162 Gillett Road, Thornton Heath, CR7 8SN

Design and Access Statement

Planning application – For proposed internal reconfiguration and refurbishment to increase the number of units with a change of use from 18 bedsits (previously) to a total of 23 HMO units.

Revision: A

DRAWING TITLE
**Second Floor
Existing & Proposed**

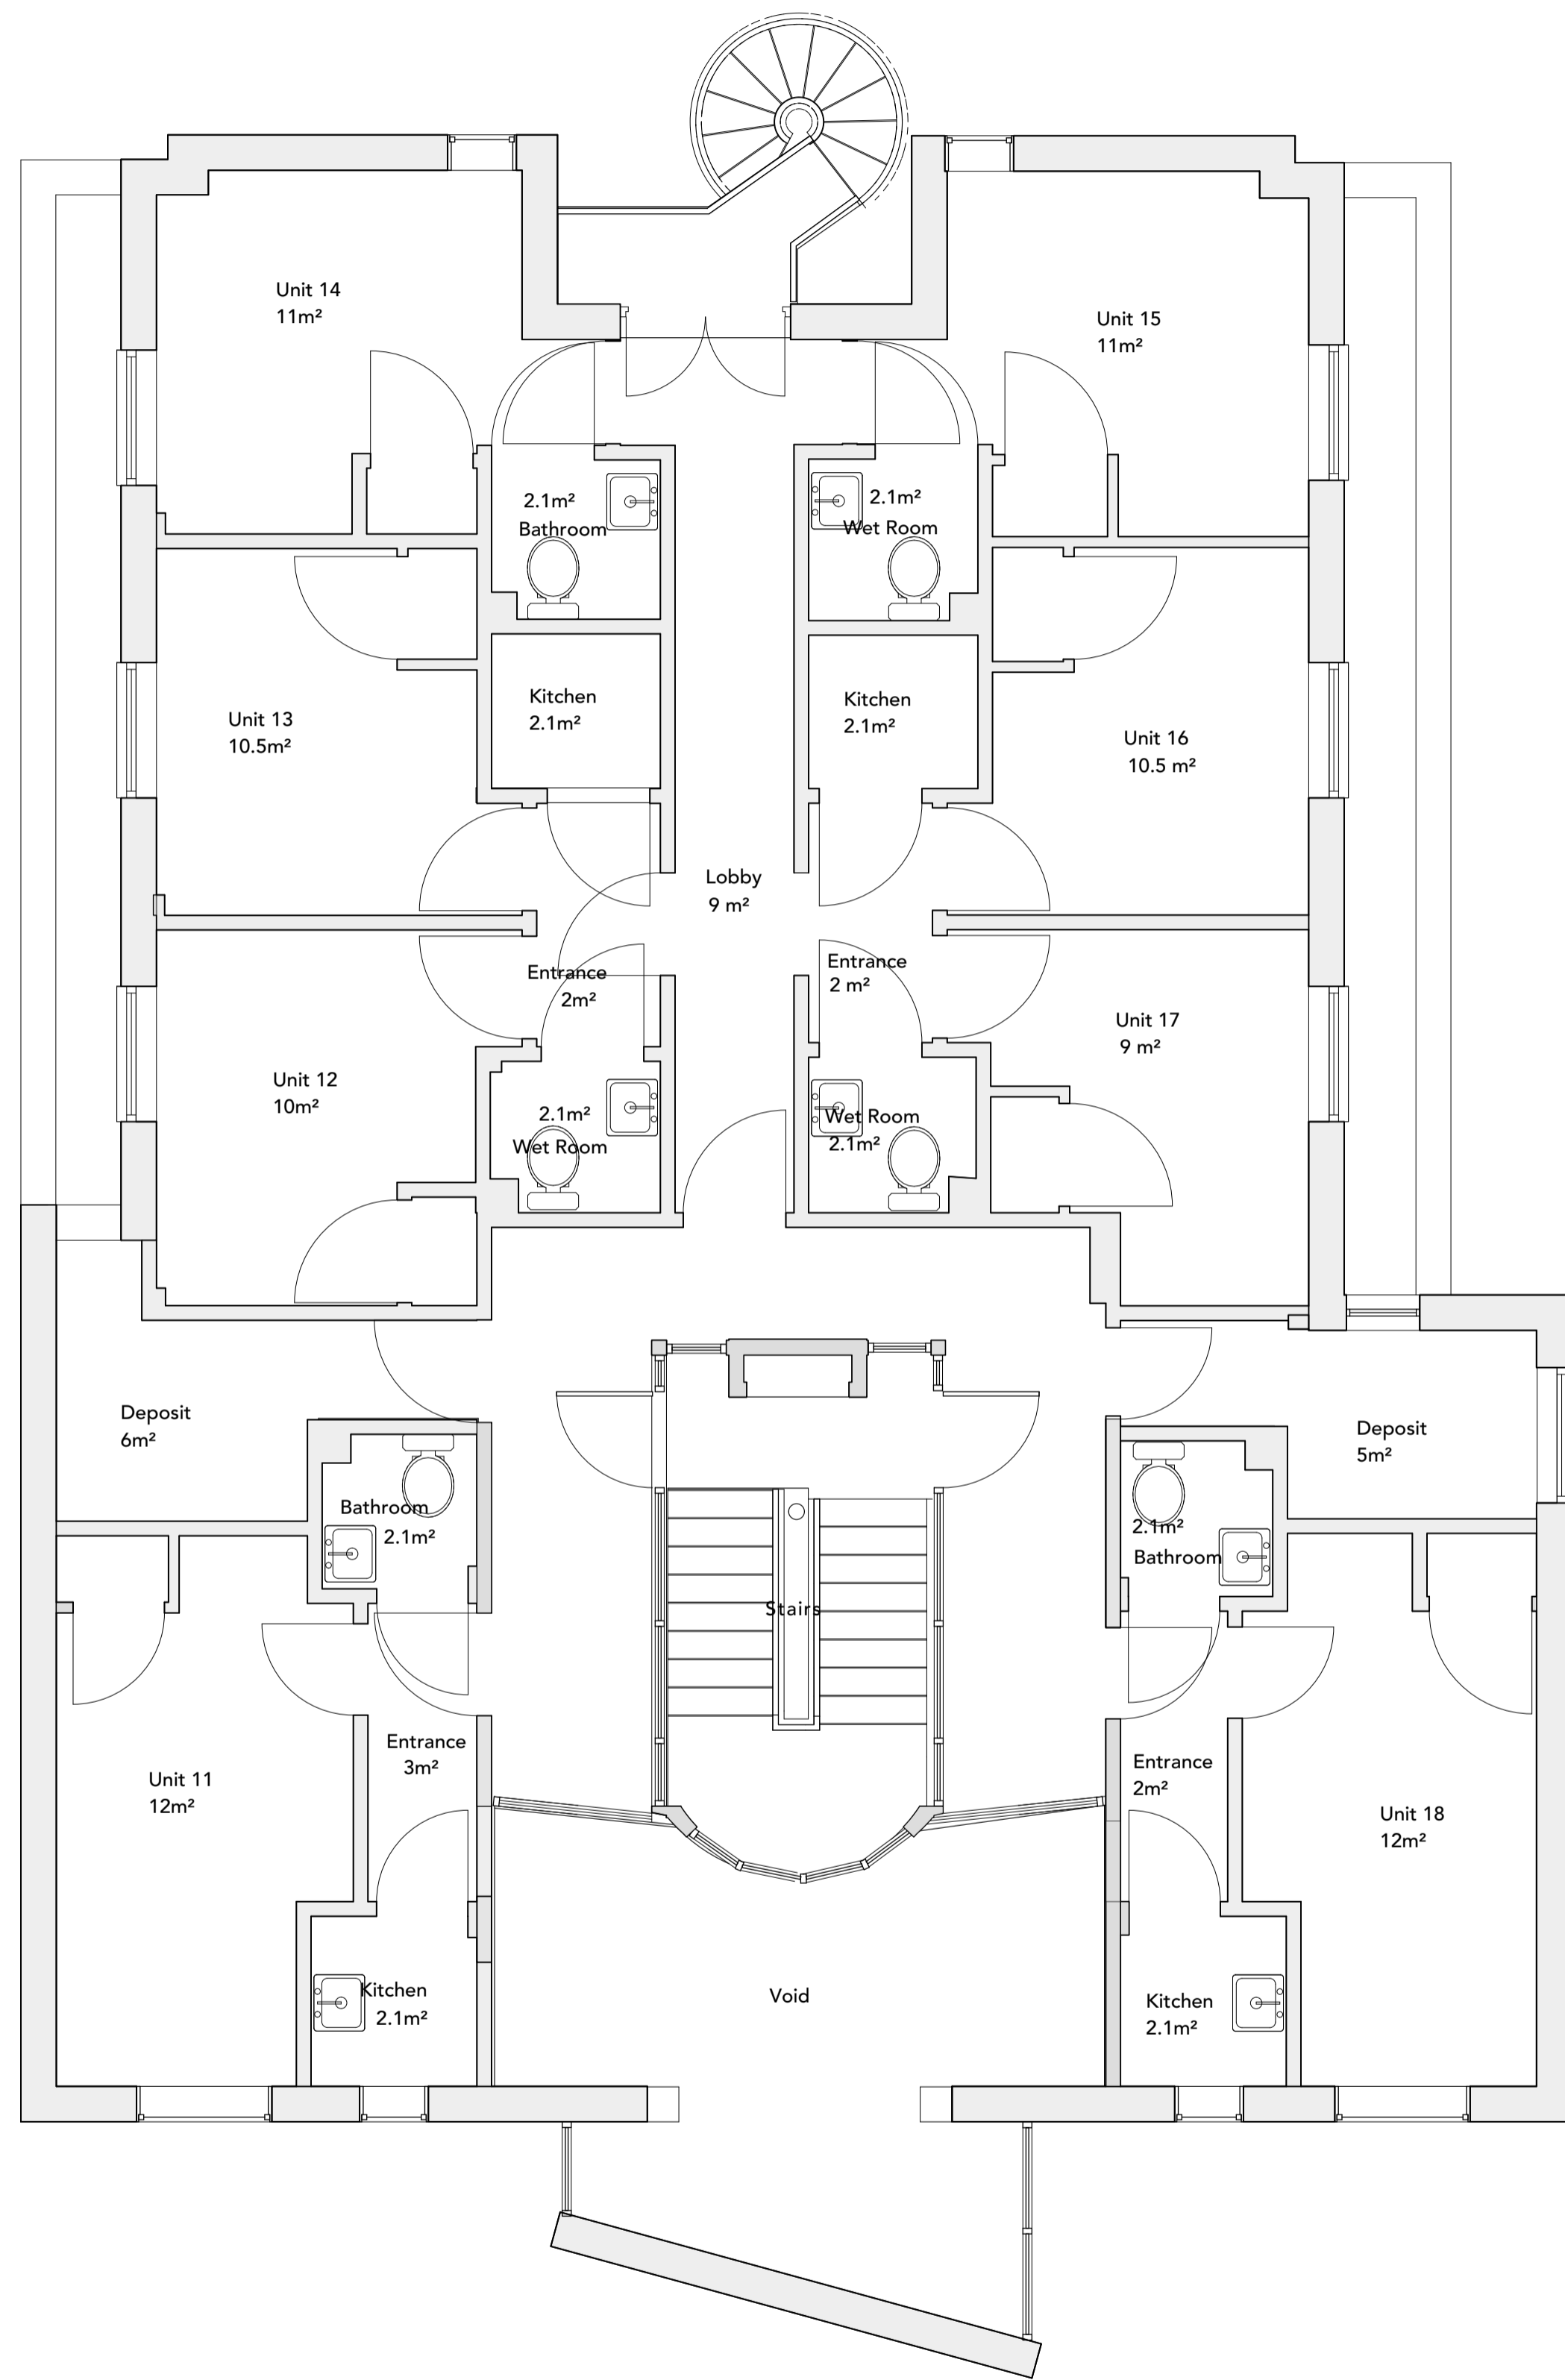
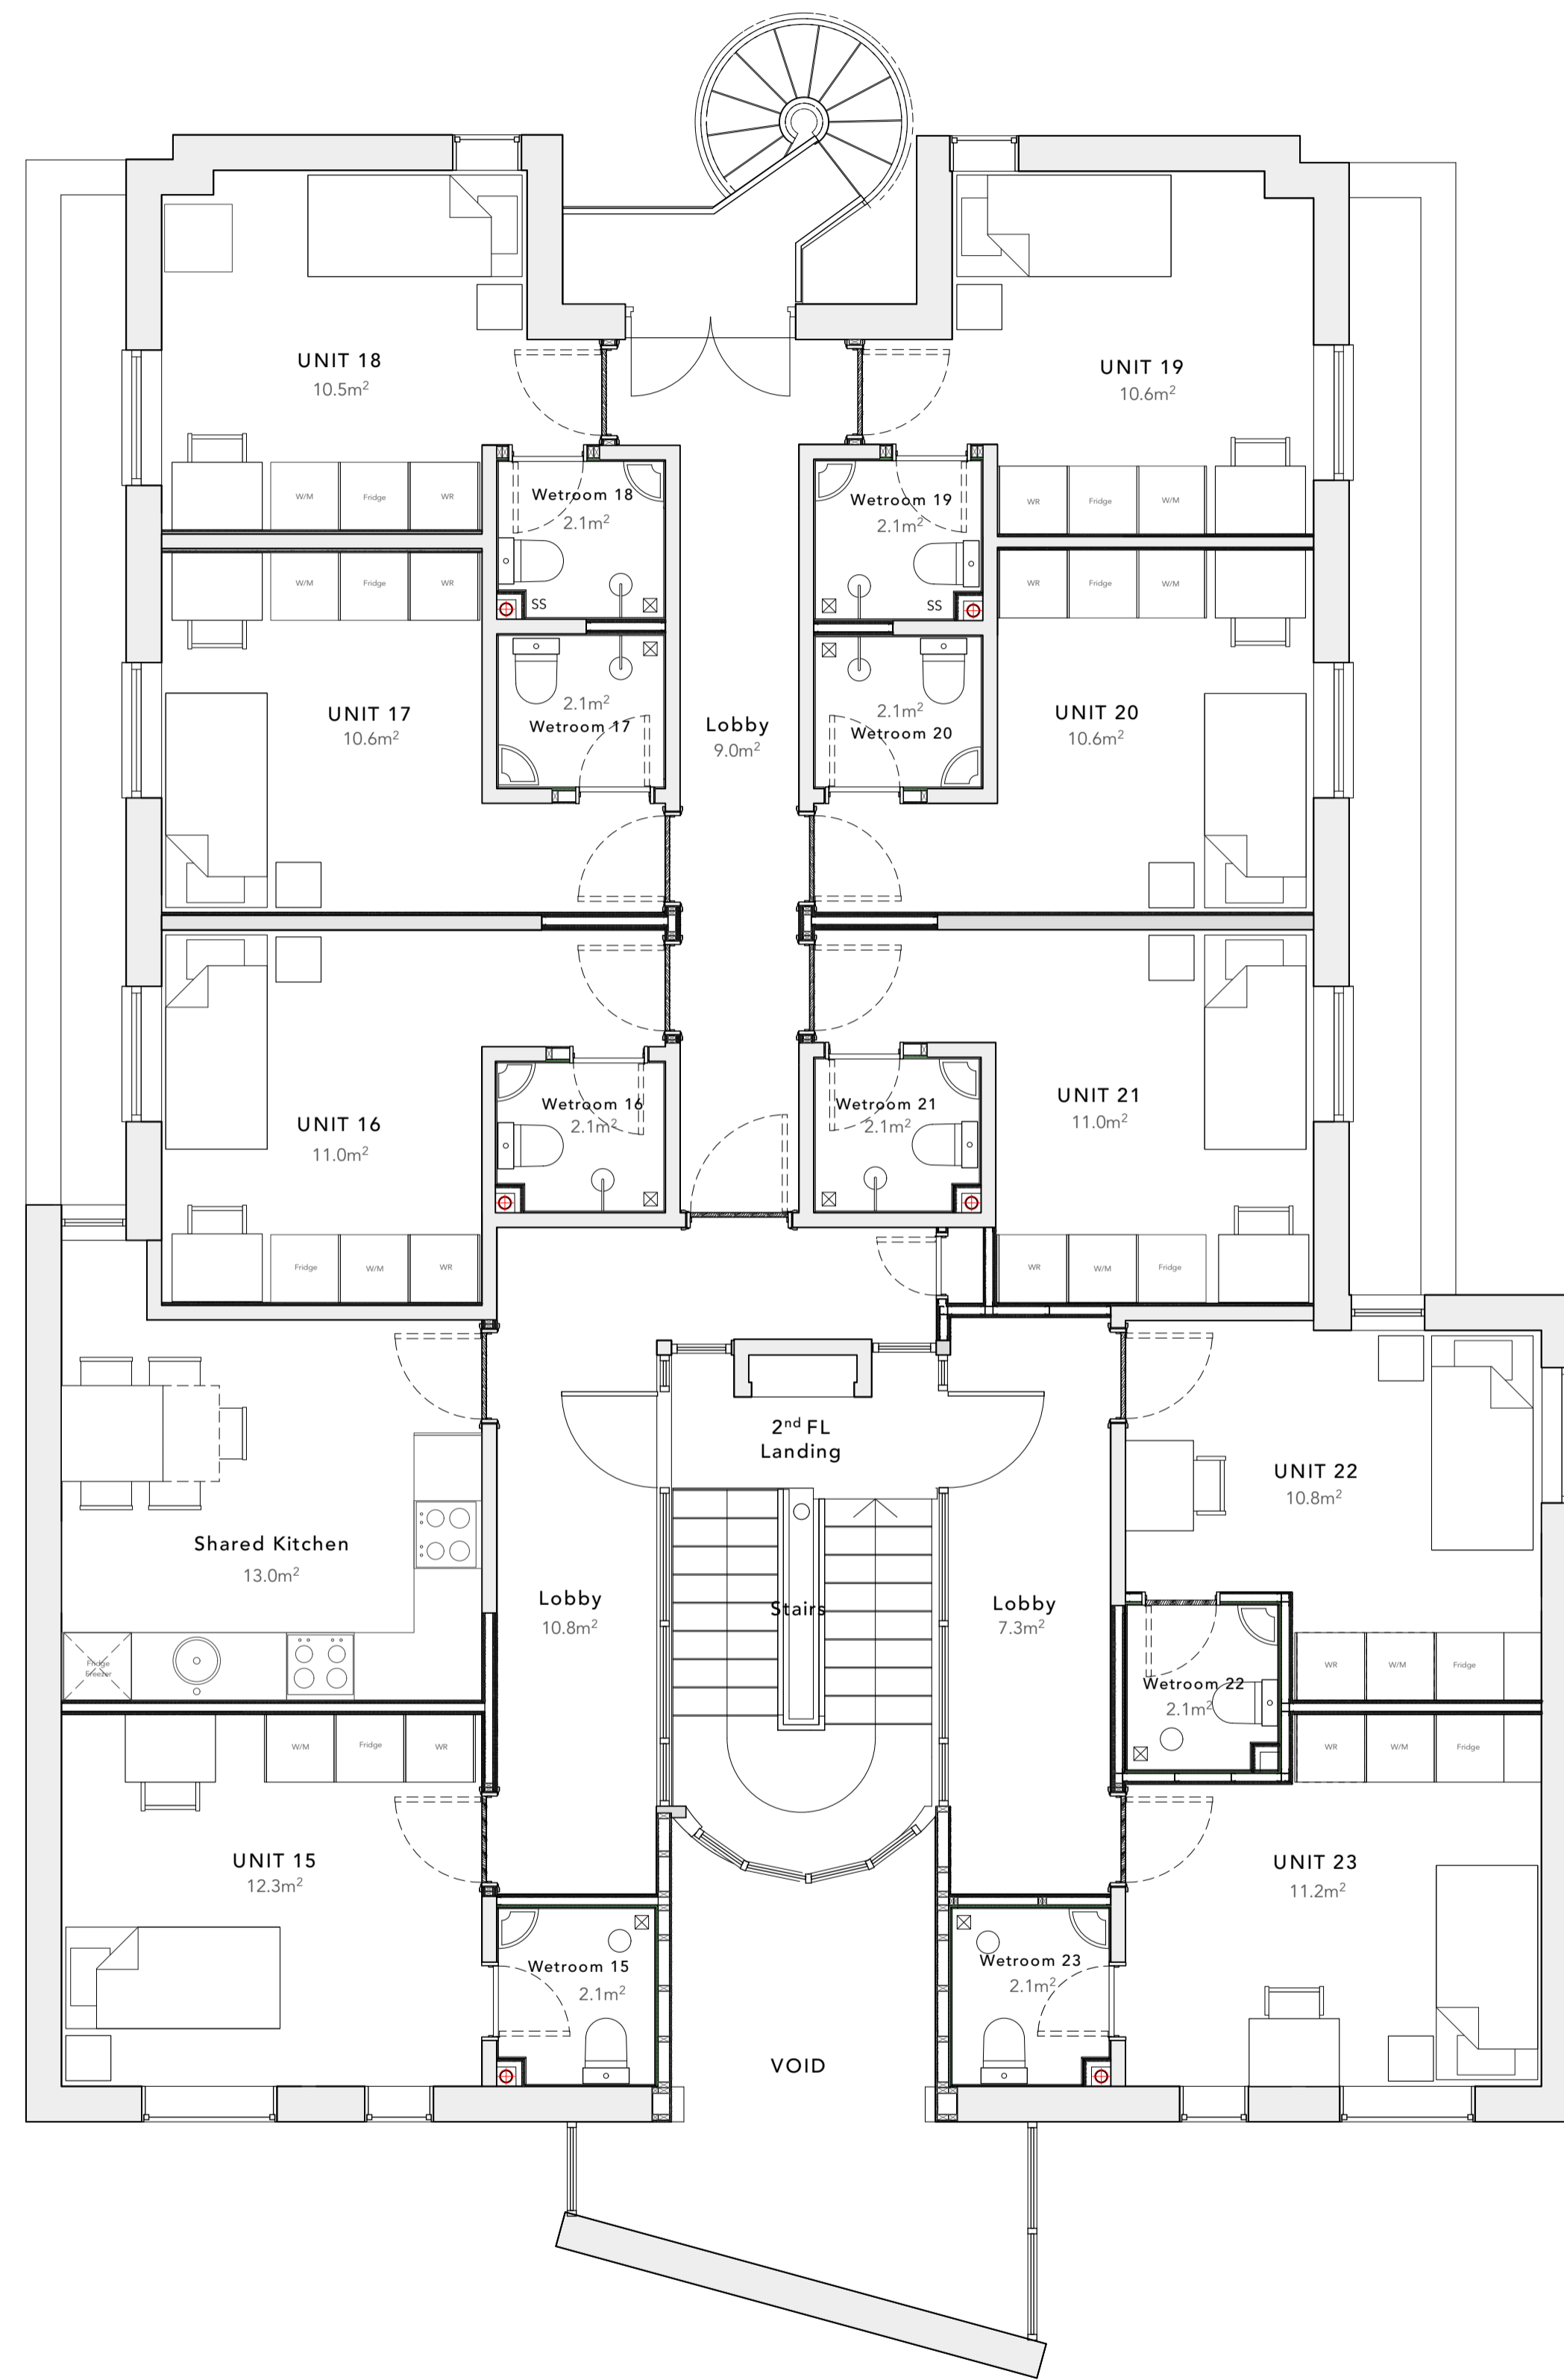
Officers comment (1): As proposed, each unit has a private kitchenette and space for a double bed and a small table. Each unit has a window for outlook and ventilation. The Council's HMO standards document outlines that a single room with a kitchen for 1 person should be 13.5sqm in area, or 18.5sqm for 2 people, whereas the proposed rooms are generally smaller than this. Wet rooms are proposed on a 1:1 basis but these are accessed from the communal corridors. The Council does not have any guidance on whether wet rooms should be accessed from private or communal spaces; this can be guided by the proposed use.

Response: All units are currently single occupancy, cooking facilities have been removed from the units on first and second floor, ensuite shower room now provided. Minimum space requirements for single rooms with ensuite shower room according to Croydon HMO standards is 12.5m² – all the rooms on the first and second floor meet those requirements.
